From: Zac Denton <Zac.Denton@arun.gov.uk>
Sent: 28 September 2020 08:15
To: Planning.Responses <Planning.Responses@arun.gov.uk>
Subject: FW: Acknowledgement for AB/82/20/L

Conservation Officer Consultation Response

PROPOSED LOWER GROUND FLOOR PLAN

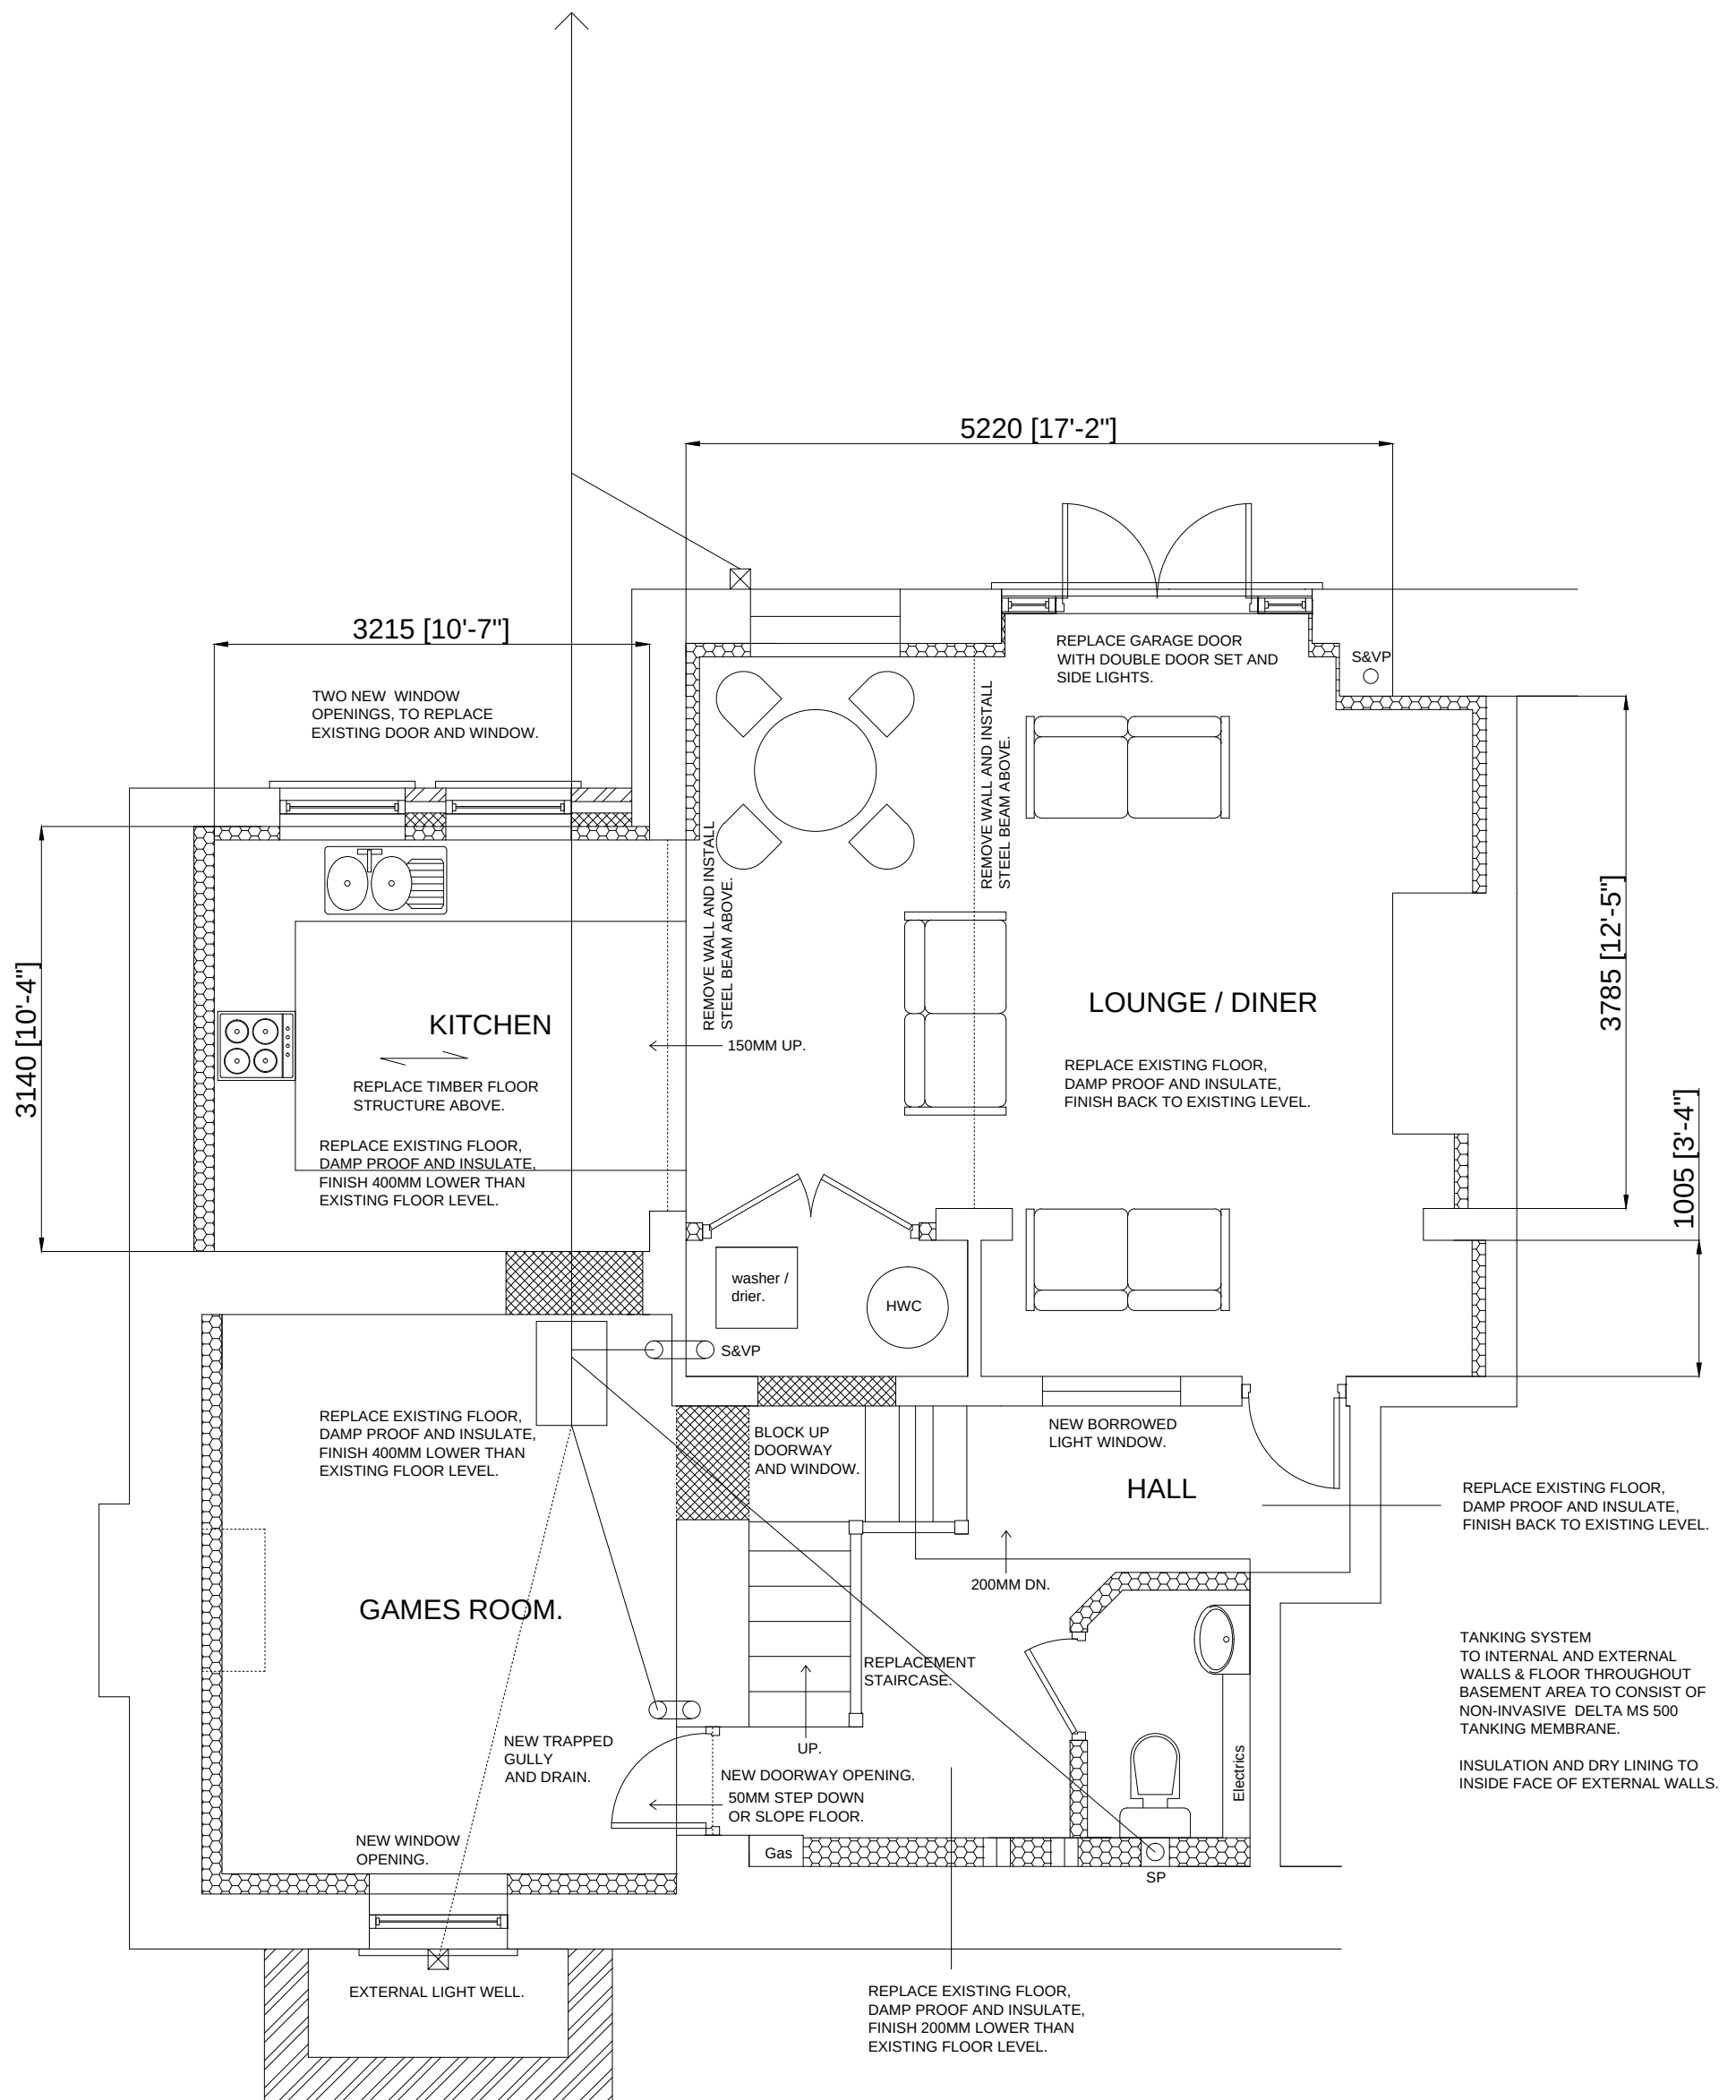
Thank you for the additional information. I am happy with the responses provided. I note that the floorboards identified as part of the work to workshop number two are believed to be traditional boards. As noted in the response, these should be retained and re-used as part of the proposed works.

1. I am happy for details of any internal door replacement and details for the new staircase design to be by way of a condition, as well as details for the internal window within the basement area.
2. I can confirm that the existing sash windows to the front are non-original and modern replacements.
3. The floor structure above workshop 2 is within the extended part of the building, thought to be of Victorian origin and therefore of less importance. The floor joists themselves appear to have been replaced in recent years and are modern machine cut timbers, as the existing joists may have previously suffered from rot. The floor boards are believed to be traditional boards and therefore we are happy to re-use these and top up with reclaimed boards if necessary. The ceiling beneath consists of modern hardboard. Overall there will be little or no loss of historic fabric in this area.
